Planning Officer: Michael Eastham

Planning Application Ref: EG/22/19/OUT

Location: Boweries, Barnham Road, Eastergate, PO20 3RT

Description of works: Outline application with some matters reserved for the erection of 28 No. dwellings, access, landscaping & associated works (resubmission following EG/42/18/OUT).

client			
Domusea Limited			
project			
The Boweries Barnham Road Eastergate			
title			
Proposed Site Layout Plan			
date	scale @ A3	drawn	chkd
May 2018	1:1000	KWF	MRL
project no.	drawing no.	rev	
1815	101	P03

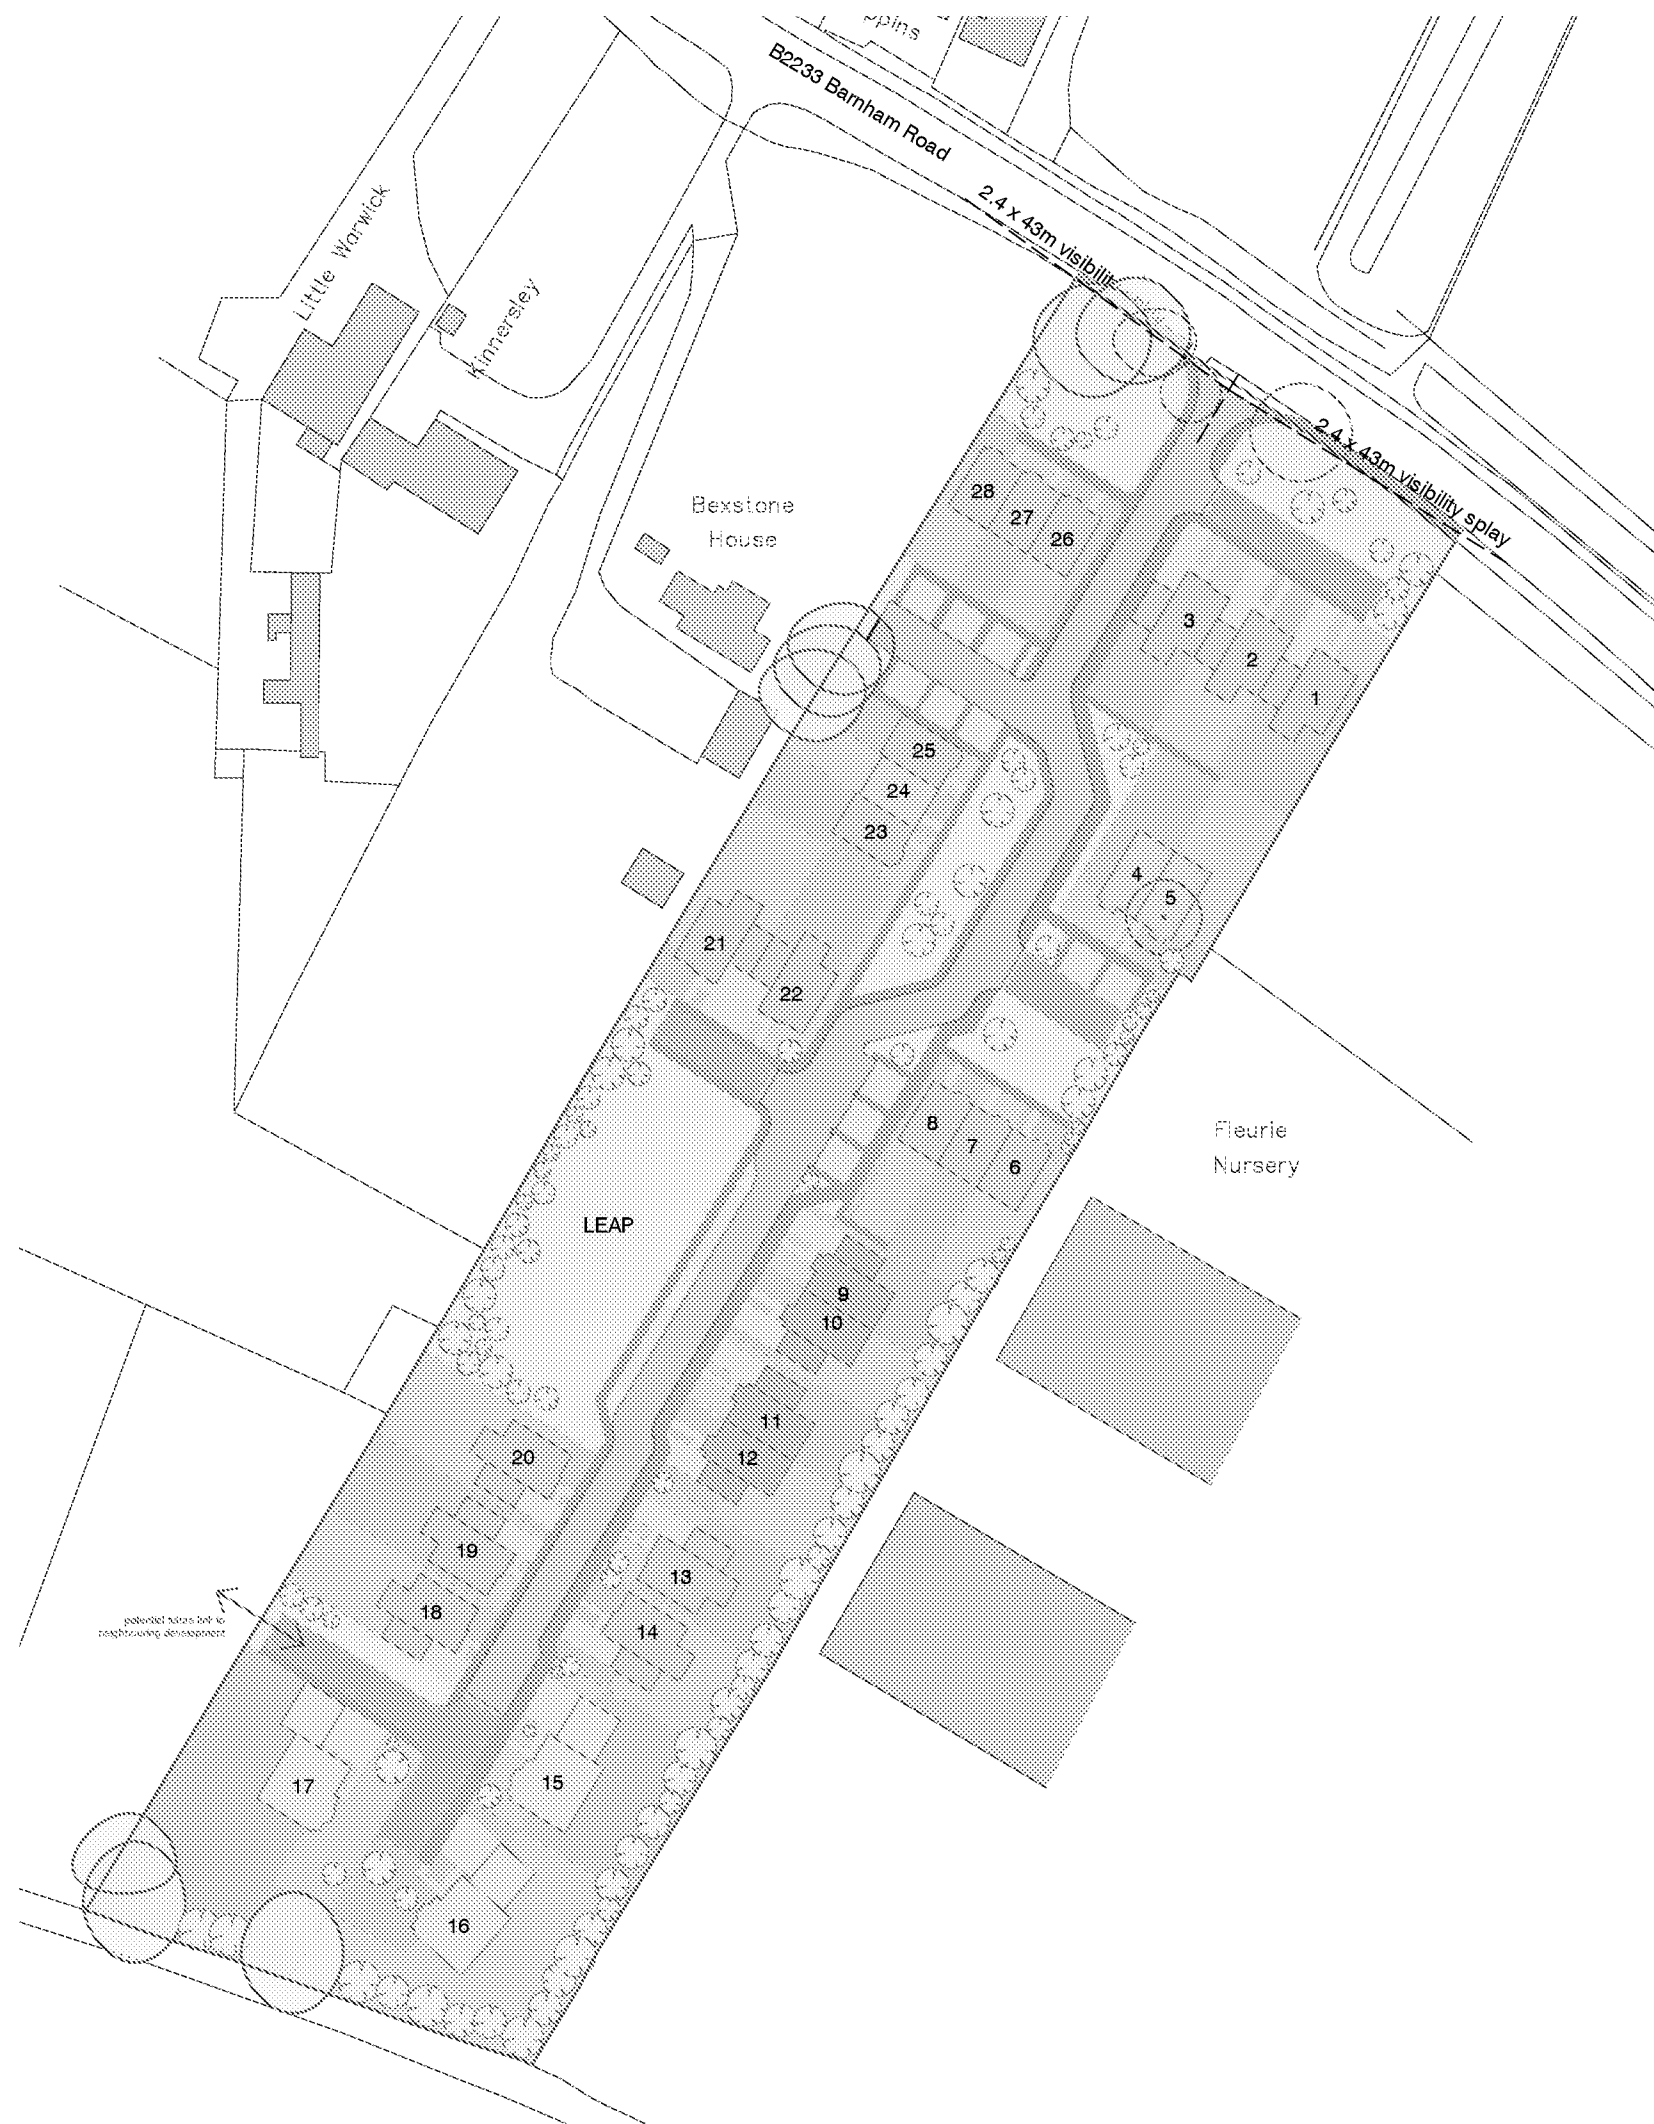
- The proposed access to the site would involve the removal of three mature trees of high public amenity value. I find this unacceptable and would expect a revised layout to accommodate those trees (recommended to be the subject of an Order) sympathetically. As such, the logical alternative for site access would be due east of T45 and its nominal root protection area (RPA).

- There are useful (ecology/screening) and visually interesting tree groups (landscape/amenity value) on the west boundary of the site, TL07 and TL19. While not individually or collectively worth of an Order (TPO), I would expect them to be accommodated in any proposed layout, with ample room so as to allow their unrestricted growth and existing nominal RPAs to be undisturbed.

- Large and prominent trees along the south boundary of the site TL01, TG02 & T03 are also useful for the reasons stated above and perhaps of greater significance for the wider area. These appear to have been given adequate room in the current proposed layout, which I would expect to remain a primary consideration.
